DRB Application No.: 06DRB-00236 (P&F)

Project Name: EAGLE ROCK ESTATES UNIT 3

- 4. Project # 1004713**
06DRB-00235 Major-Vacation of Public Easements
06DRB-00236 Minor-Prelim&Final Plat Approval

CITY OF ALBUQUERQUE
PLANNING DEPARTMENT
DEVELOPMENT REVIEW BOARD

PLAT OF
LOT 9-P1
BLOCK 2
UNIT 3
EAGLE ROCK ESTATES
WITHIN THE
ELENA GALLEGOS GRANT
PROJECTED SECTION 13
TOWNSHIP 11 NORTH, RANGE 3 EAST, NMPM
CITY OF ALBUQUERQUE
BERNALILLO COUNTY, NEW MEXICO

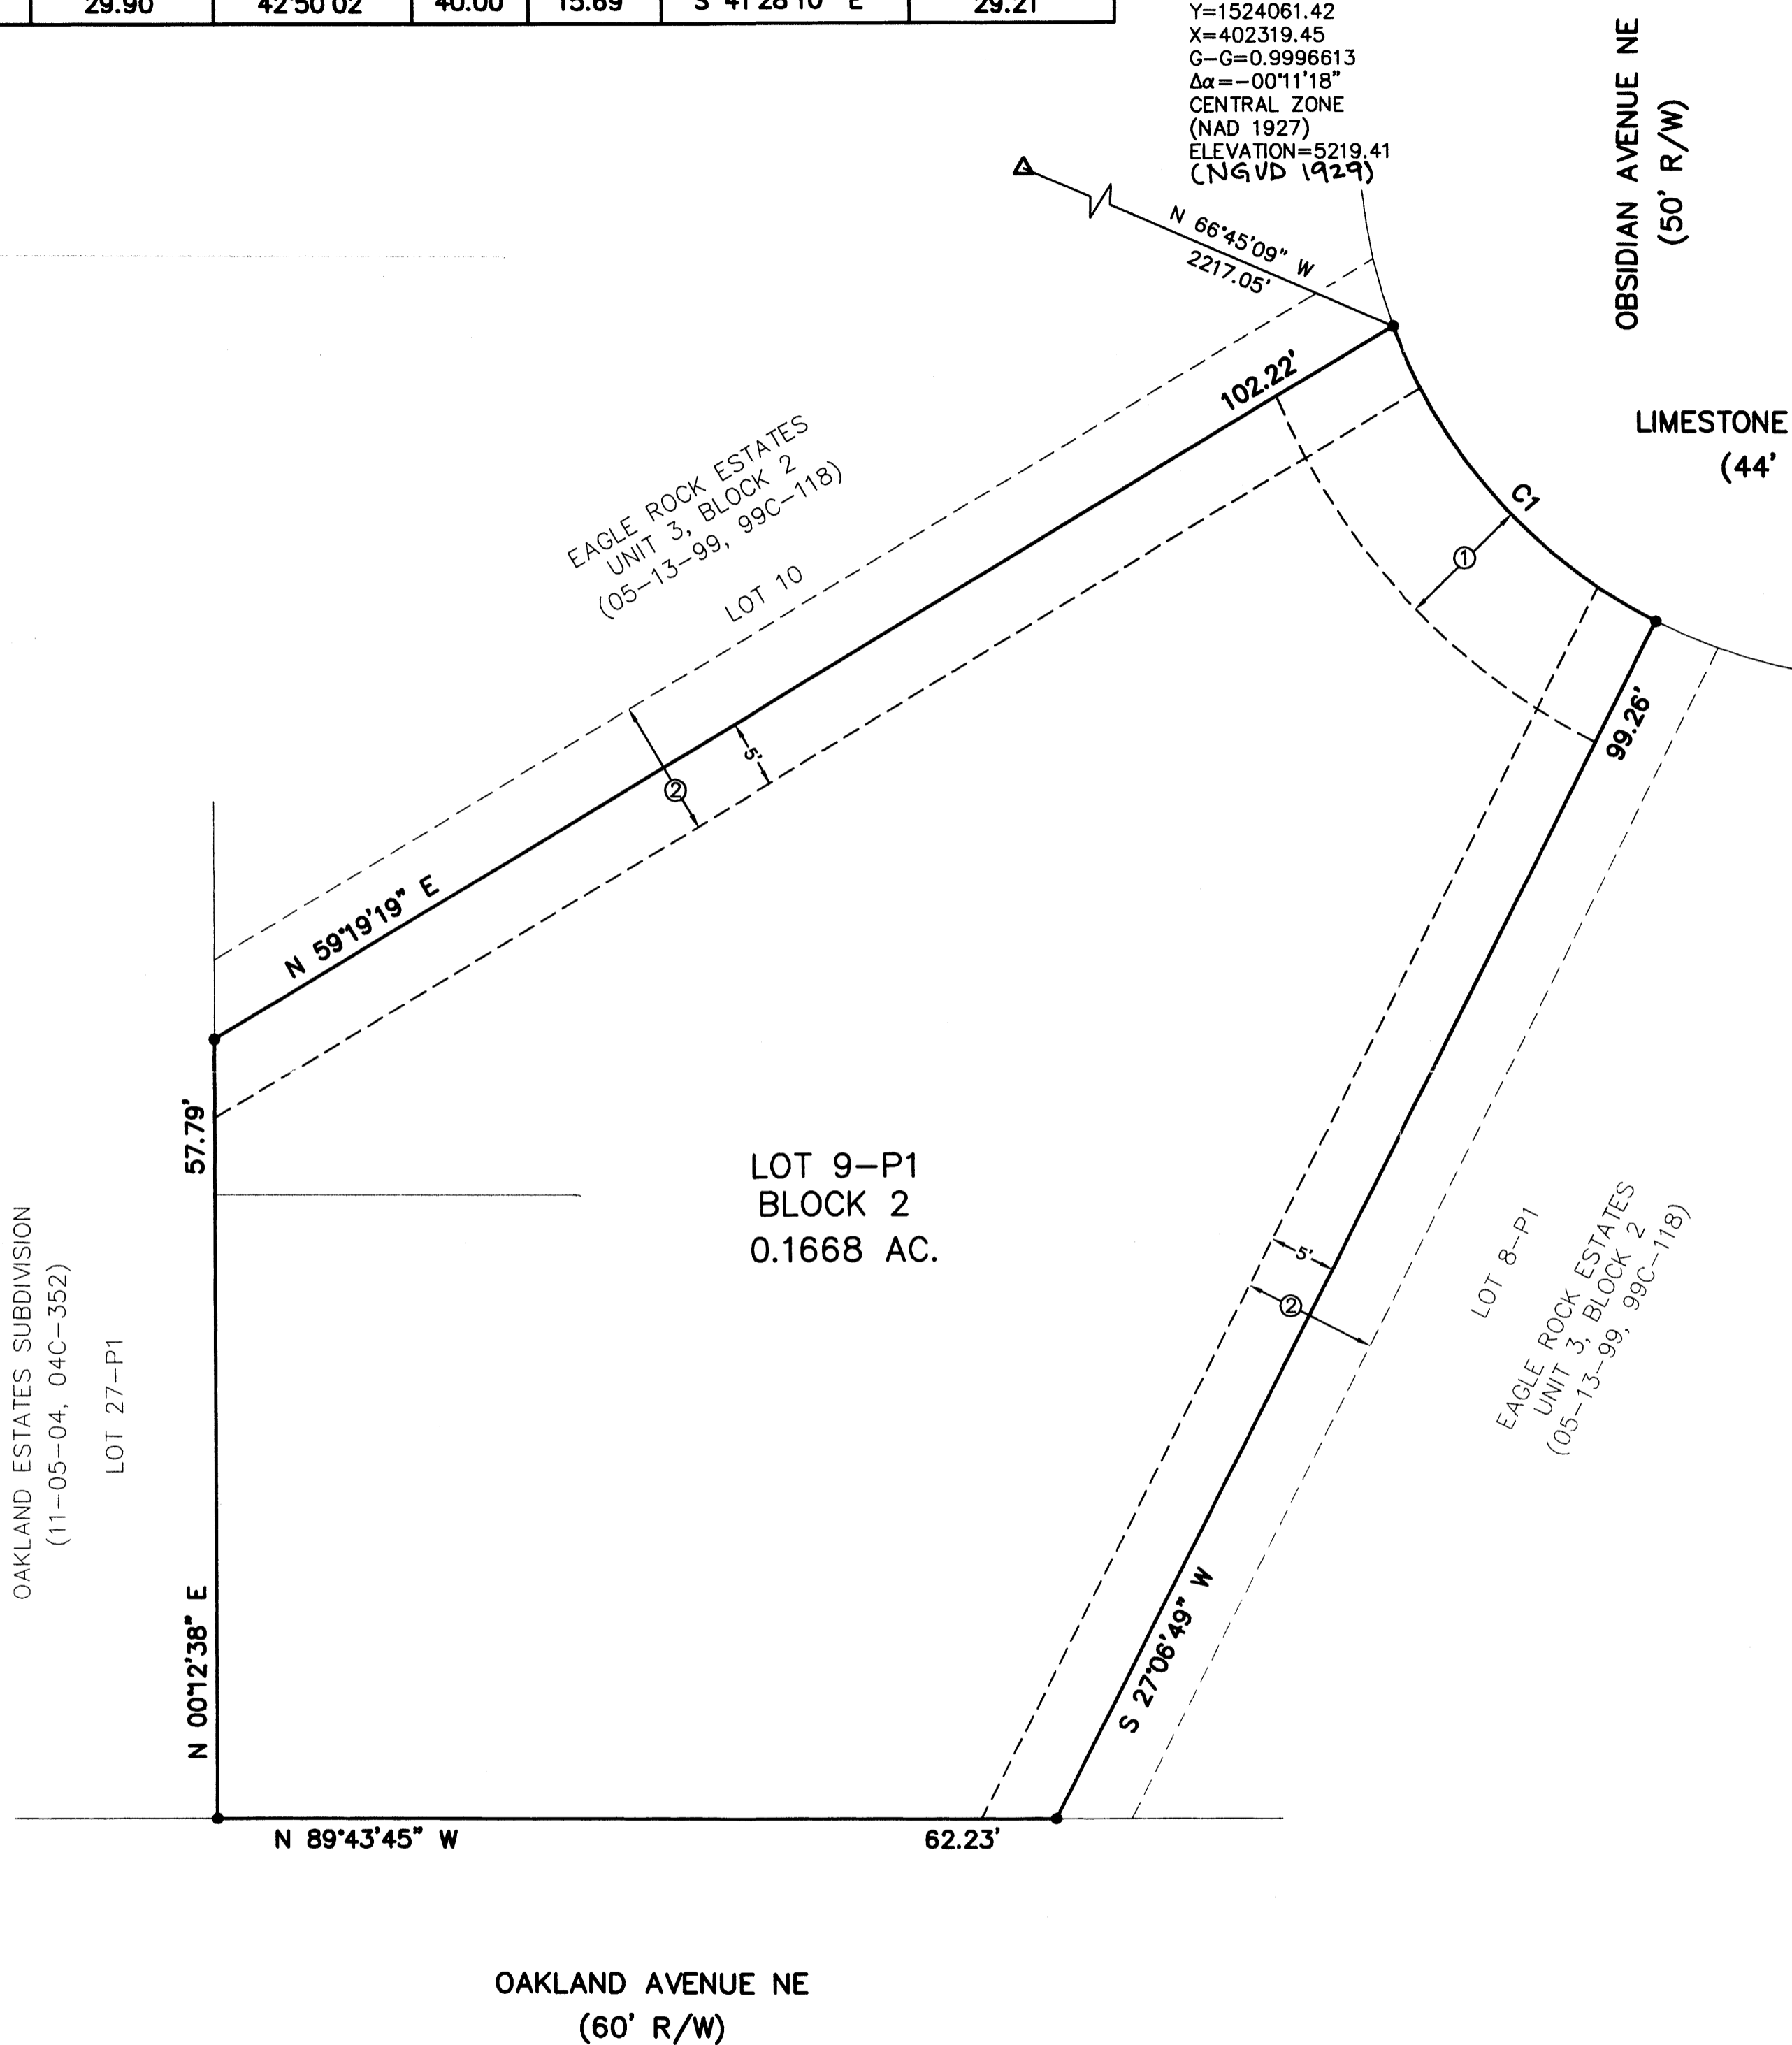
No objection to the vacation. Planning defers to Hydrology. The plat is missing the current zoning. It should appear under Subdivision Data. Planning will take delegation for the 15 day appeal period.
